Planning Inspectorate reference: EN070008

APPLICATION BY CHRYSOR PRODUCTION (UK) LIMITED (THE APPLICANT) FOR A DEVELOPMENT CONSENT ORDER FOR THE VIKING CCS PIPELINE (EN070008).

NOTIFICATION OF INTENTION TO SUBMIT AN APPLICATION FOR CHANGE REQUEST

TITLE: THE THEDDLETHORPE FACILITY PLOT PLAN

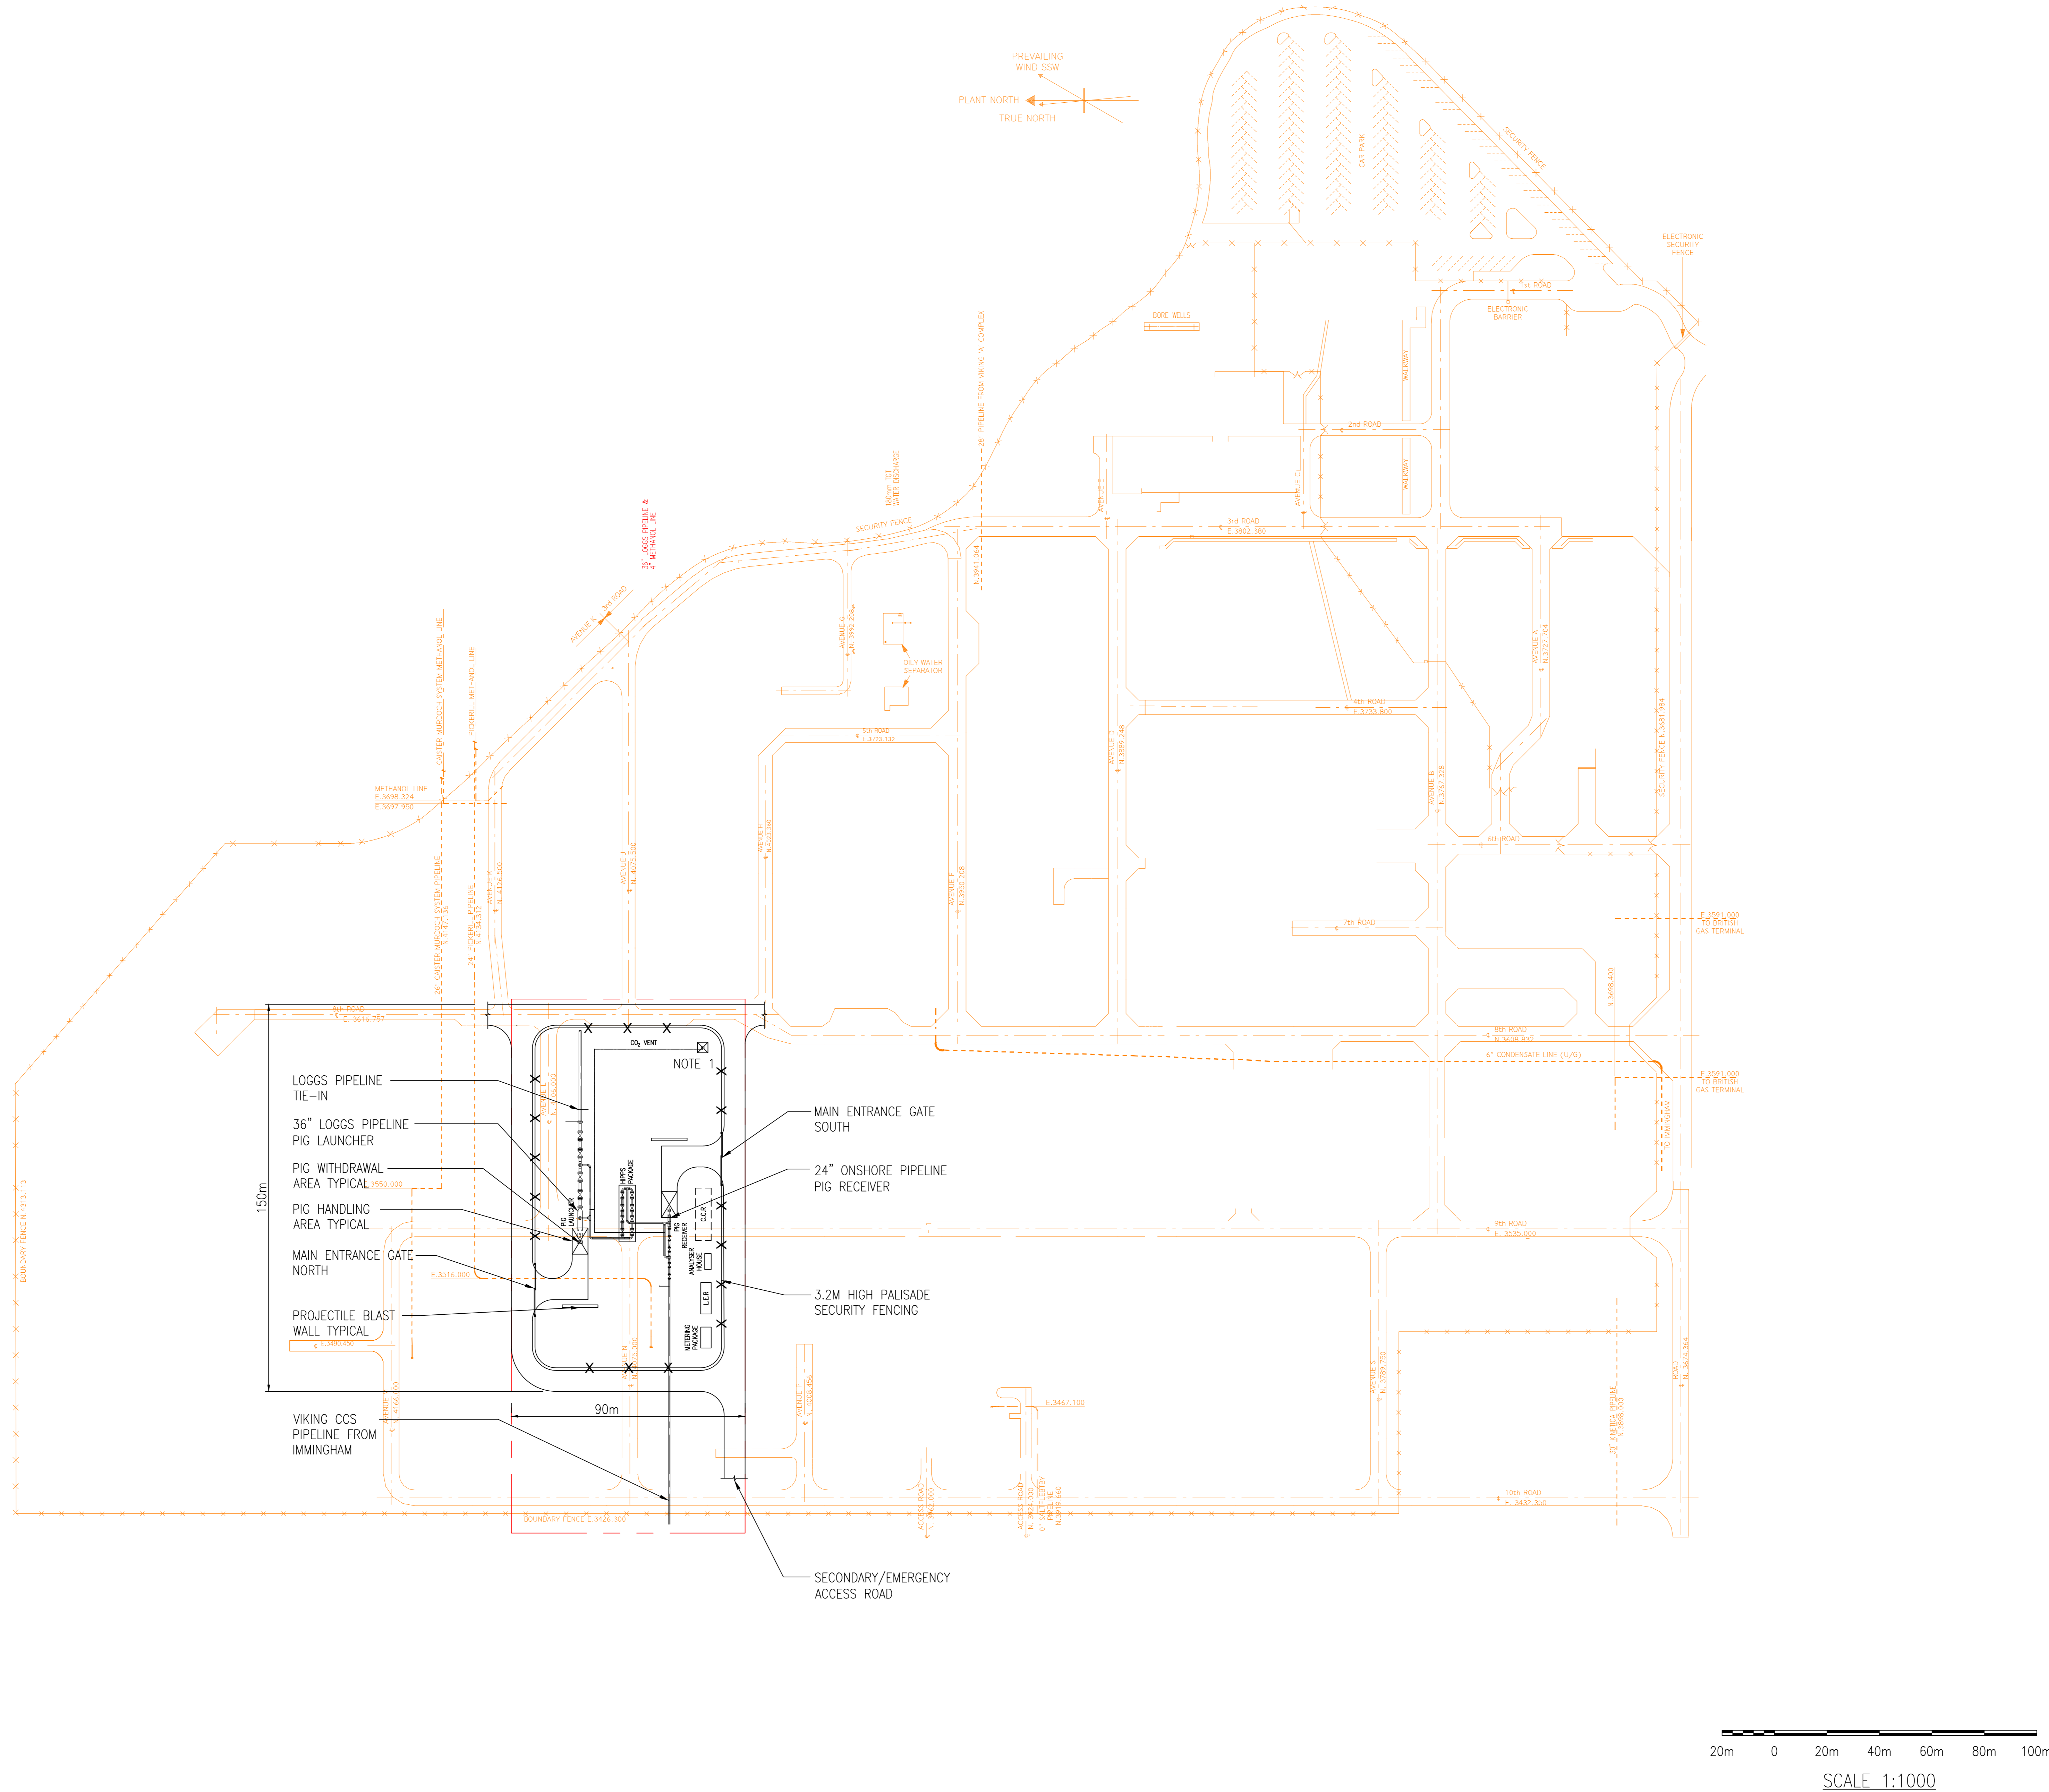
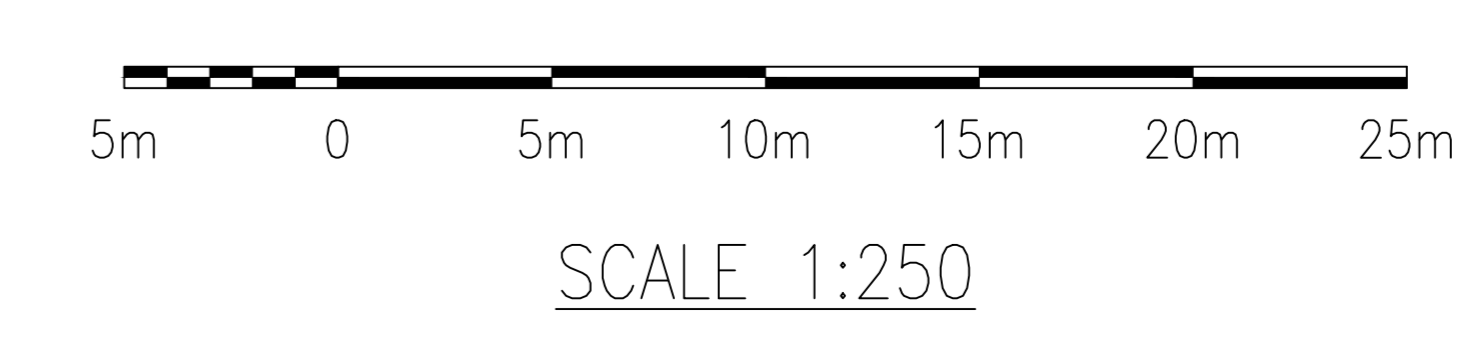
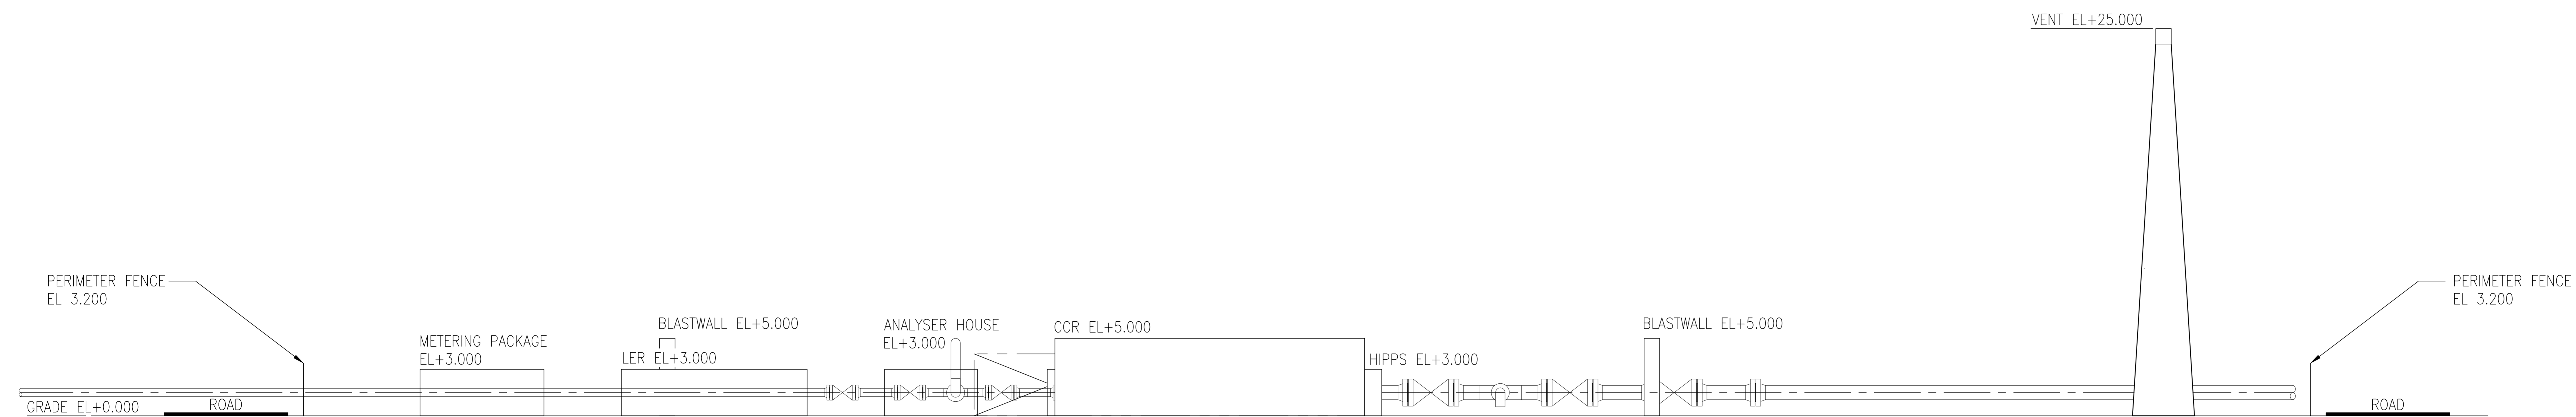
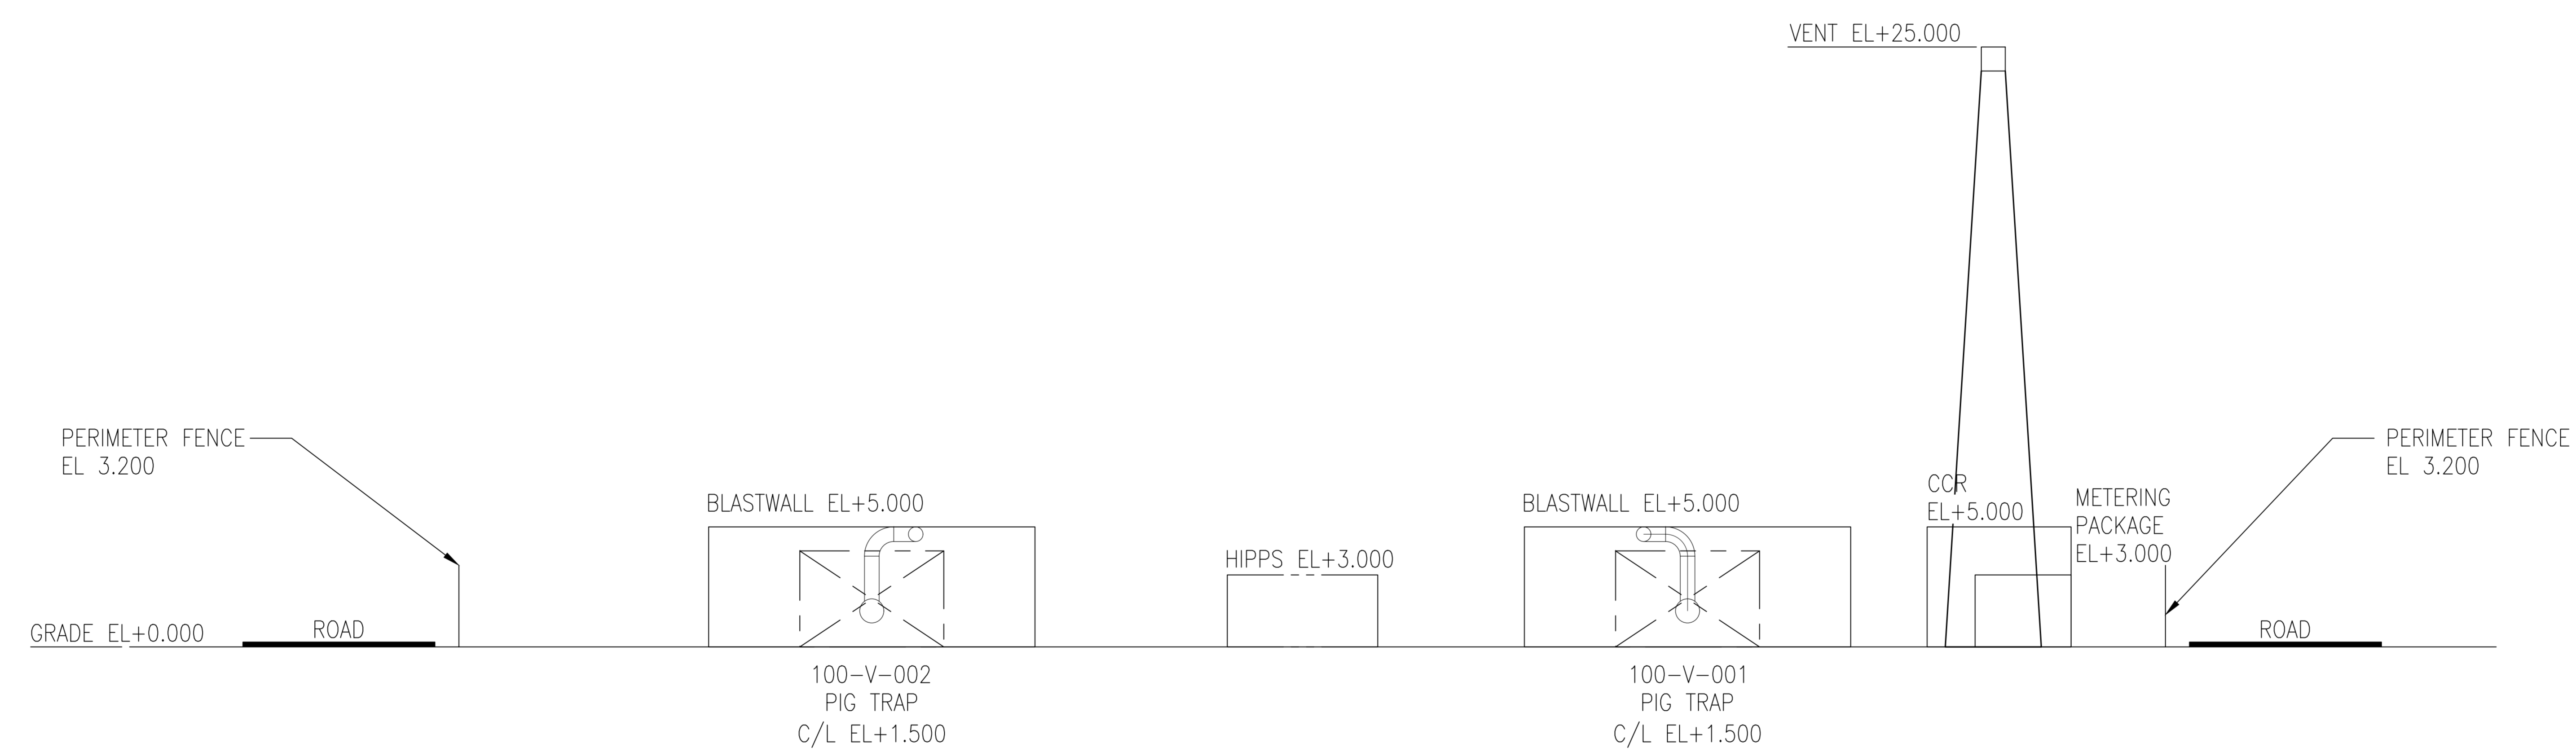
Change 5: Removal of Theddlethorpe Facility Option 2 from the Application (Removal of Work No. 42 from the Order Limits)

At the point of submission, the Applicant included a degree of flexibility and optionality relating to the location of the Theddlethorpe Facility. The Theddlethorpe Facility will comprise the infrastructure necessary to enable CO₂ to flow from the new 24" pipeline into the existing LOGGS (36") pipeline, then onwards to be stored in the depleted gas fields within the southern North Sea. The Proposed Development included optionality for the location of the Theddlethorpe Facility, which is set out in Chapter 3 of the ES [APP-045]. This optionality was included due to uncertainty about potential alternative plans that National Gas Transmission ("NGT") (as landowner) had for the former TGT site. The following options were included as potential locations for the Theddlethorpe Facility:

- **Option 1** - would be located on previously developed land at the former TGT; and
- **Option 2** - would be located on arable land directly west of The Cut (an ordinary watercourse) and accessed from the north off the A1031 Mablethorpe Road.

The Applicant and NGT have now reached agreement on the terms of a voluntary agreement, with engrossed versions of those agreements now going through the final corporate approval processes of the respective organisations. As a result of this progress, the Applicant is now confident that Option 2 is no longer required and the Applicant will submit a change request for this to be removed from the Proposed Development.
